Response to Planning Application

From: Arun District Council Greenspace

Application ref: BN/54/21/DOC

Location: Land Rear Of 1 Northfields Cottages Fontwell Avenue Eastergate PO20 3RX

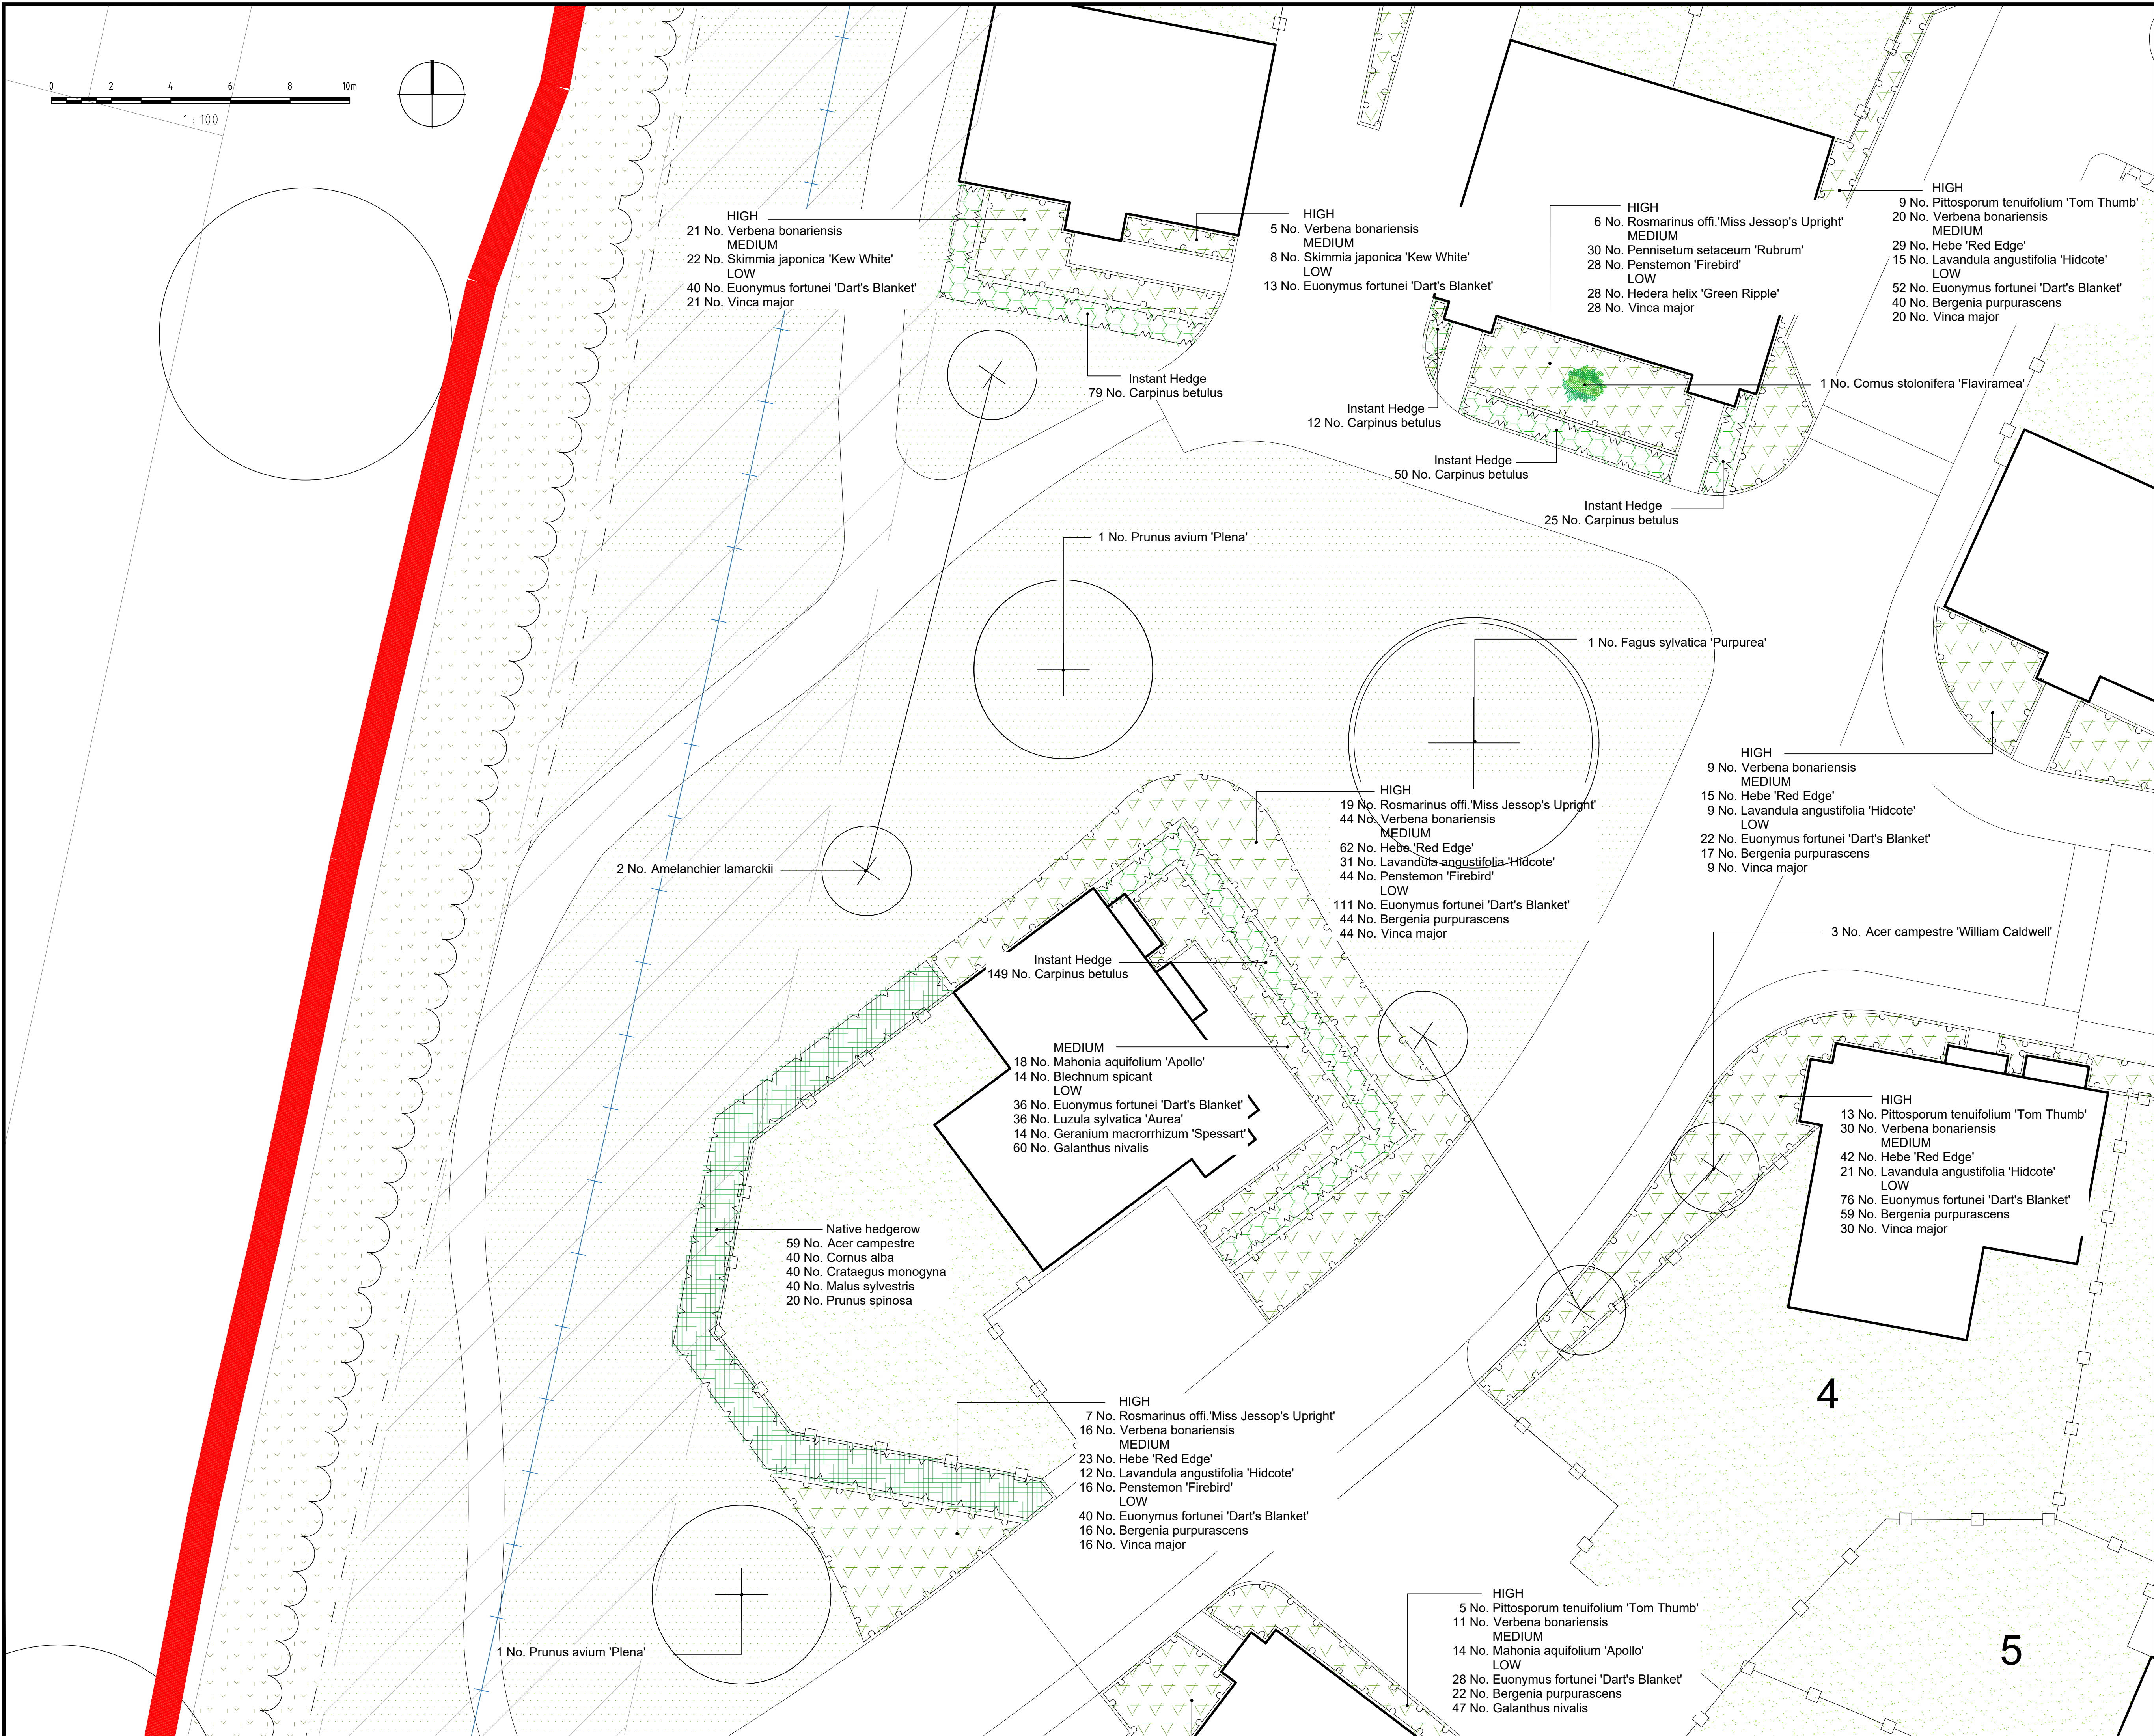
The proposed landscape detail specified in Detailed Planting Plans 1-8 L01- L08 and Coloured Masterplan dwg D2776-FAB-00-XX-DR-L-1000 Rev PL02 have proposed a scheme which would be fitting for location and contains detail including species choice, quantities being proposed, planting densities and size at time of planting.

There would not appear to be any drawings showing which detail the previously agreed play provision of timber fitness items into the POS areas to the n/west area of the site. The Coloured Masterplan dwg D2776-FAB-00-XX-DR-L-1000 Rev PL02 needs to reflect these items and location of these.

Recommend the discharge of Condition 17 Landscaping scheme on this application BN/54//21/DOC imposed under BN/50/19/PL, **subject to** the submission of additional drawing which shows the previously agreed play provision of timber fitness items into the POS areas to the n/west area of the site.
